## ARBORIST CORRECTIONS

**Project Name:** Mercer Island Treehouse

**Site Address:** 5637 East Mercer Way, Mercer Island, WA 98040  
King County Parcel # 1924059312

**Date:** August 12, 2022

Proposed Site Plan:

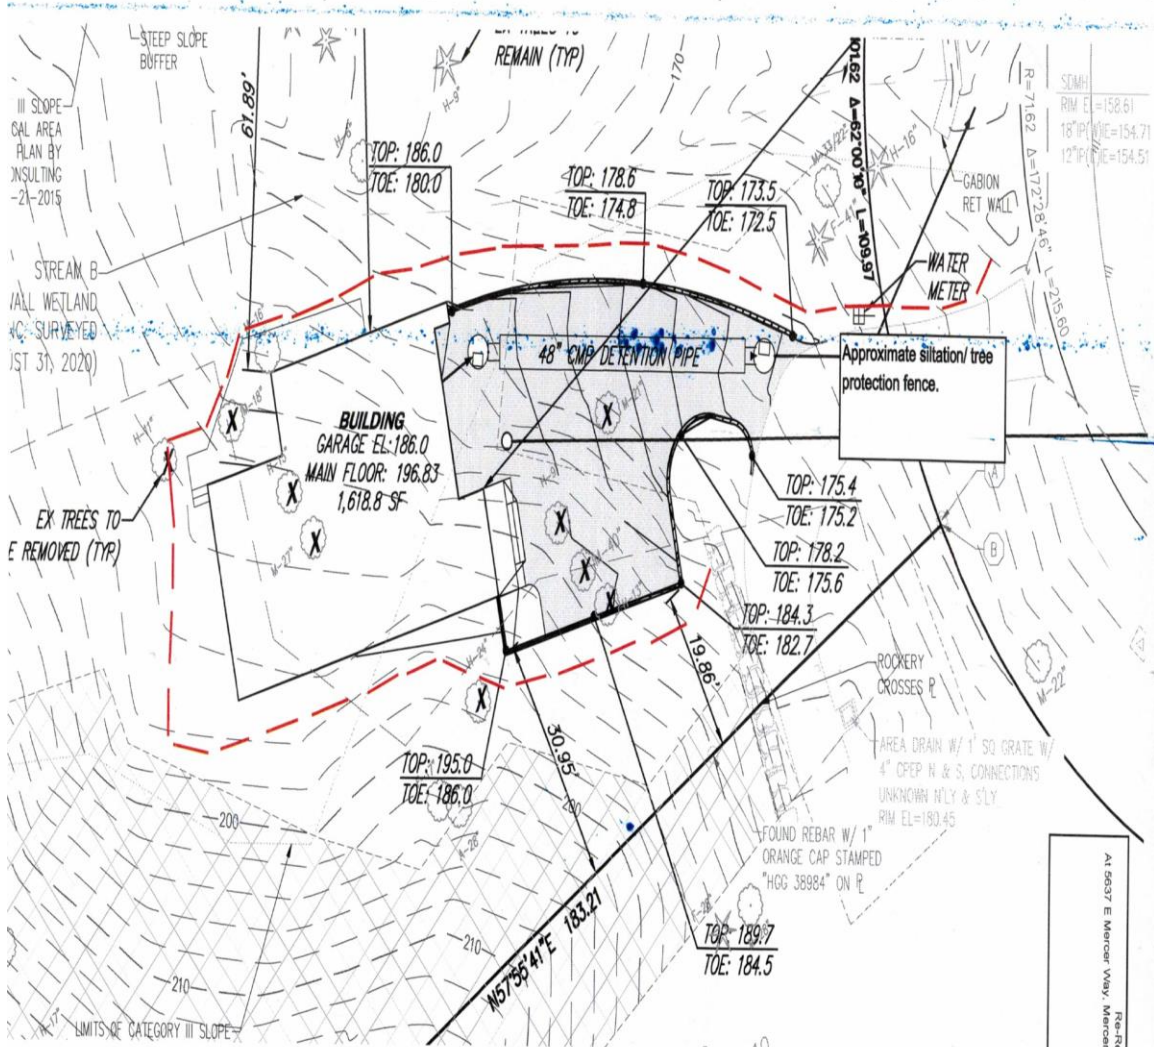
1. (From Intake for Architect/Arborist/Civil) Several exceptional trees are proposed for removal. Justification for each exceptional tree removal is required under 19.10.060.A.3. Trees 976,982 are exceptional and proposed for removal. Tree 986 was also required to be retained as part of a plat condition according to the arborist report. A modification to the detention tank to retain the tree was recommended. Update the plans with this proposal to save the tree. ¶

TREE-REVIEW#  
2. (For-Civil/Arborist)-Limits-of-allowable-disturbance-will-be-determined-by-the-arborist-for-all-exceptional-and-saved-trees-showing-development-within-their-driplines.. This-root-zone-analysis-should-be-determined-by-noninvasive-techniques-such-as-air-excavation.. These-limits-must-meet-the-standards-in-MICC19.10.080.. The-arborist-must-how-the-code-will-be-met.. These-limits-of-allowable-disturbance-will-be-shown-and-called-out-on-the-civil-plans. ¶

3. (For Civil) A tree protection plan is required according to the following checklist. No tree numbers matching the arborist report are shown for example. Trees driplines need to reflect the measurements in the arborist report. Update the tree protection plan with suggestions in the arborist report the civil information. [https://www.mercerisland.gov/sites/default/files/fileattachments/community\\_planning\\_amp\\_development/page/21988/treessubmittalchecklist.pdf](https://www.mercerisland.gov/sites/default/files/fileattachments/community_planning_amp_development/page/21988/treessubmittalchecklist.pdf)

Great effort and expense have gone into the design of the improvements with the express effort to retain tree # 986.

To this end, the detention tank has been modified as required.

In previous reports tree protection measures were clearly outlined. These measures are called out on the Civil Plans as required.

Tree tag numbers and driplines have been added to the plans as required.
